| Application number: 2025/92713   |                                                                                  |
| What is the application for?:    | Reserved matters application pursuant to outline permission 2023/92079 for erect |
| Address of the site or building: | Rear of, 23 to 43, Moor Lane, Gomersal, Cleckheaton, BD19 4LF                    |

A revised Flood Exceedance Plan PV2511 - APP - 92 - XX DR-C-2501 Revision 2 was submitted on the 13th November 2025.

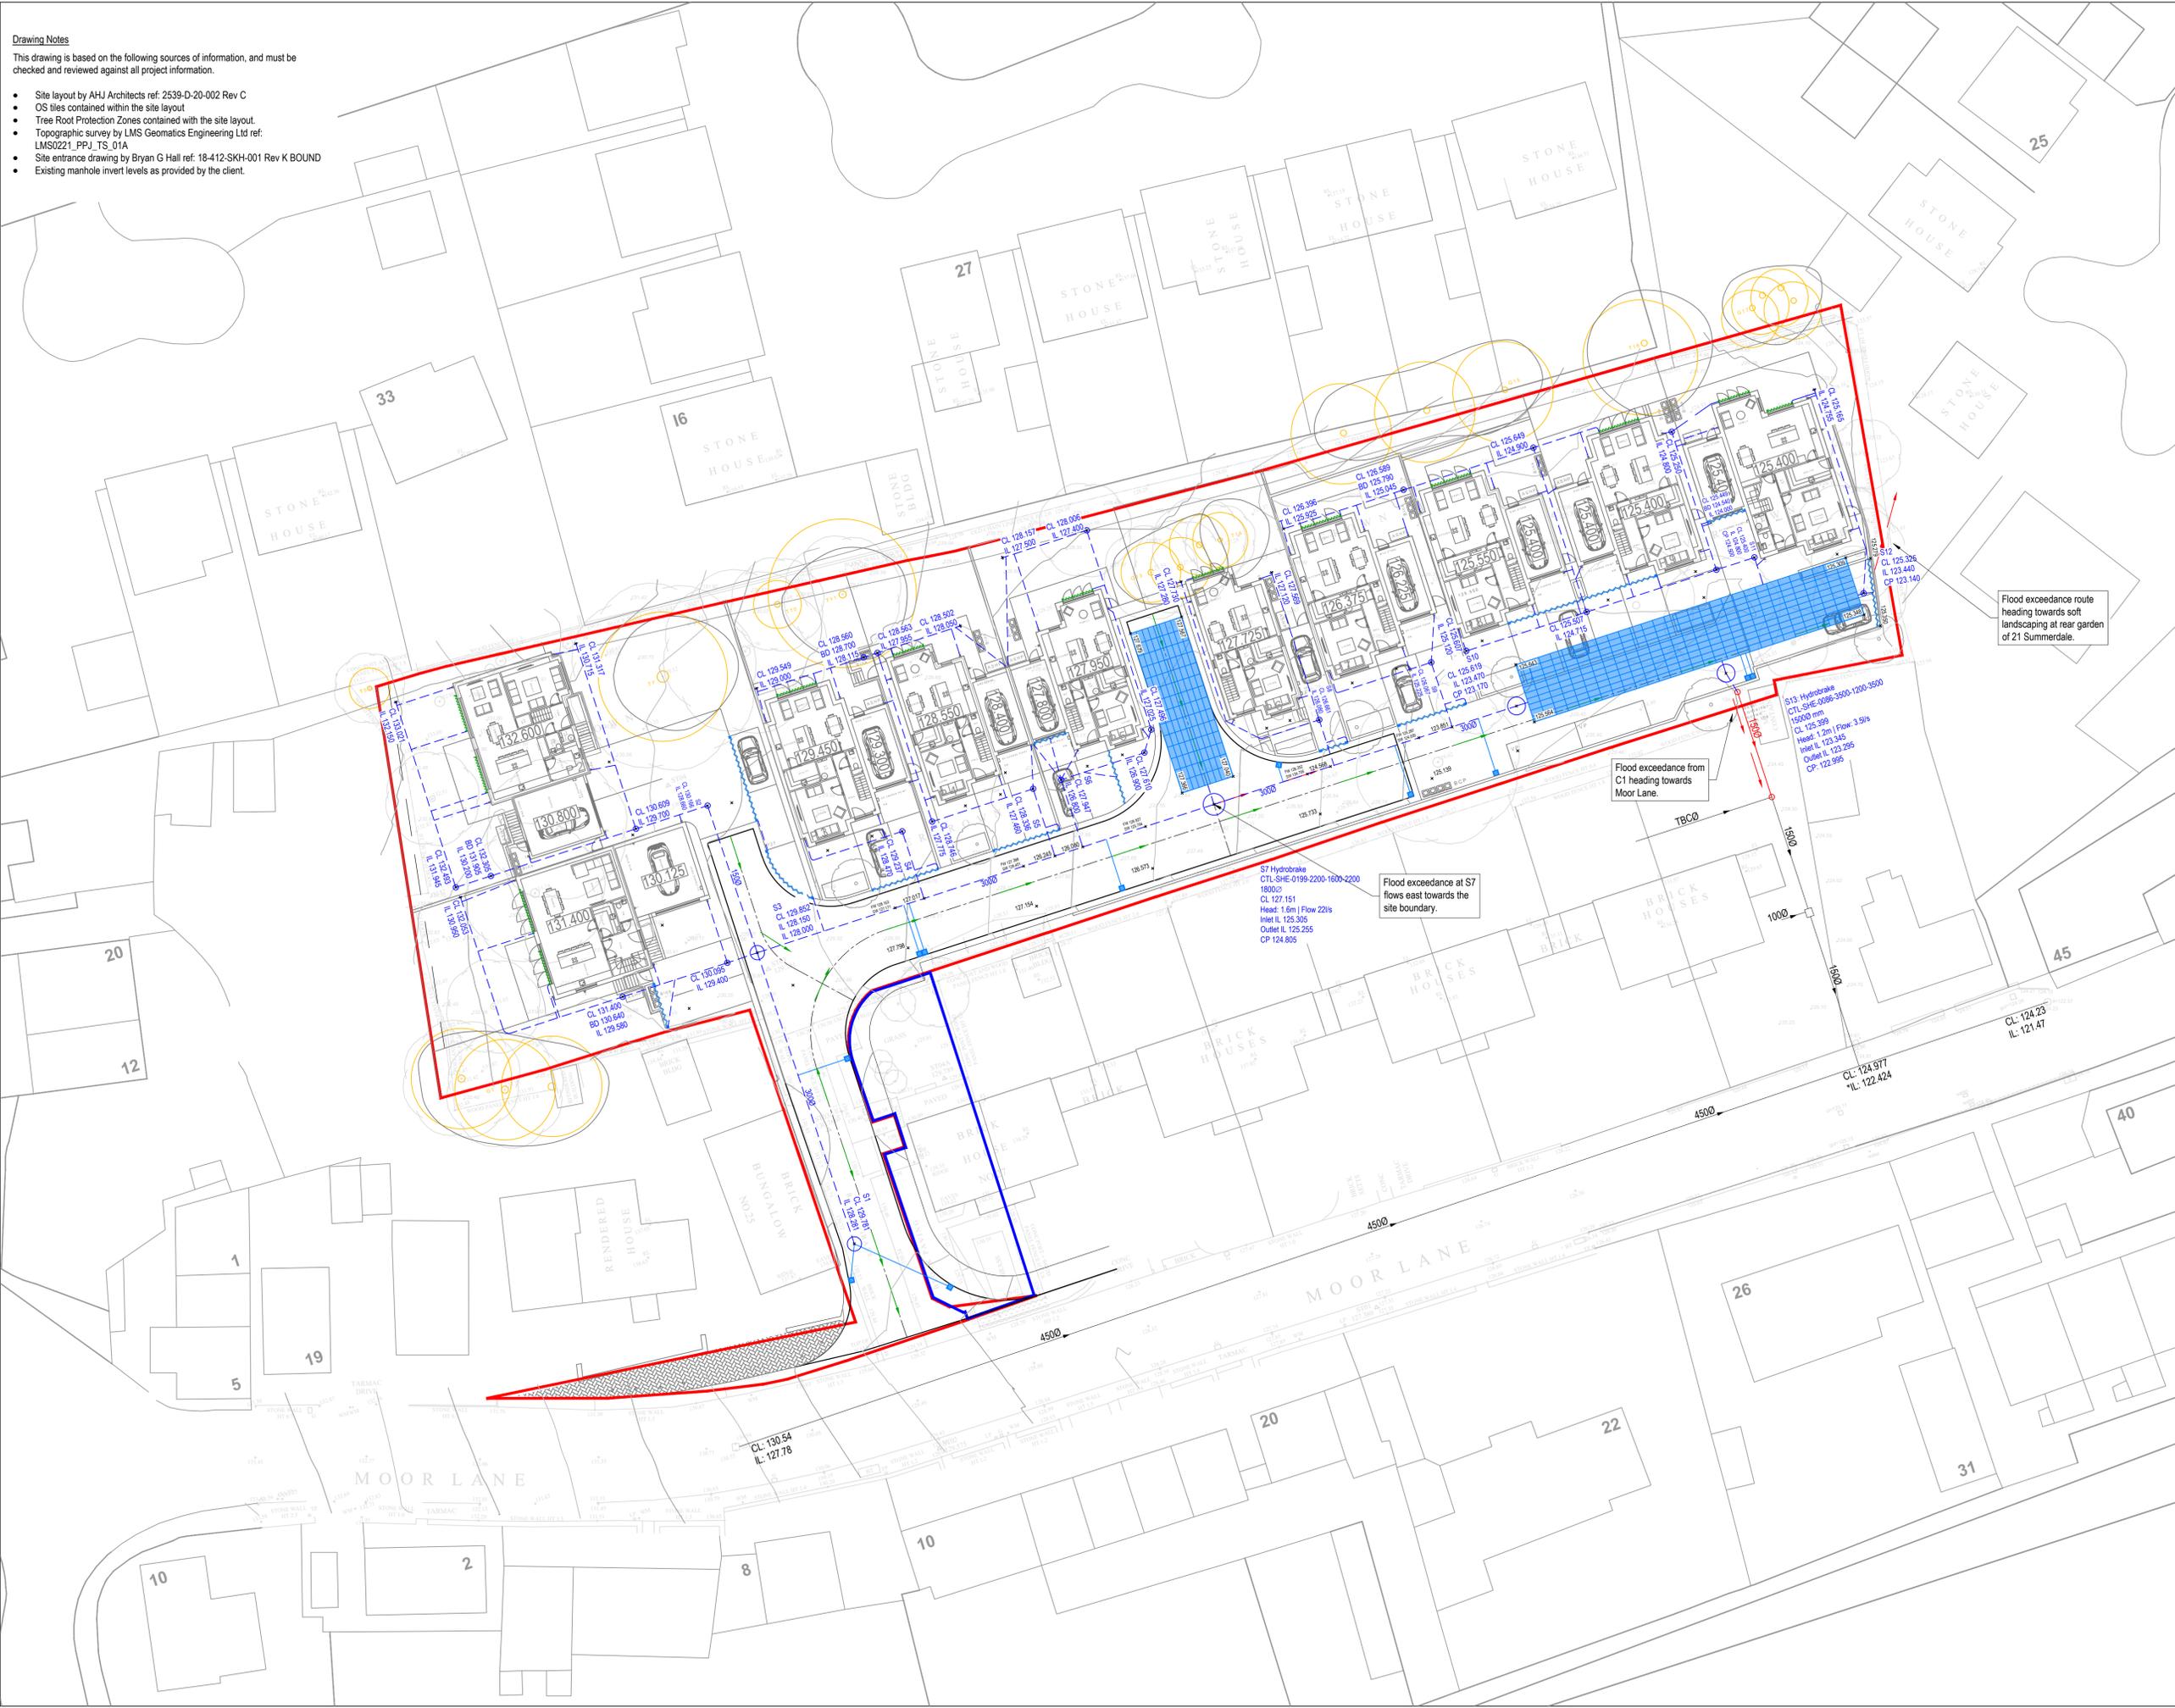
Something I find strange is that the overland "Flood Exceedance Route" which originally was shown heading into the garden of 19 Summerdale has been changed, and is now shown routed into the garden of 21 Summerdale.

Neither of these routes are acceptable as flood exceedance should not be taken into third party land without permission, and I know that permission into the the garden of 21 Summerdale hasn't ( and won't ) be granted.

If the underground drainage from the site does get approved for routing through the garden of 41 Moor Lane, then why not route any overland flood water in this direction too.

A proper above ground hard surfaced, fully contained channel with suitable kerbs to prevent water affecting neighbouring properties, could be incorporated into the design. With appropriate levels, run off water could then be directed into Moor Lane, away from any existing gardens and properties.
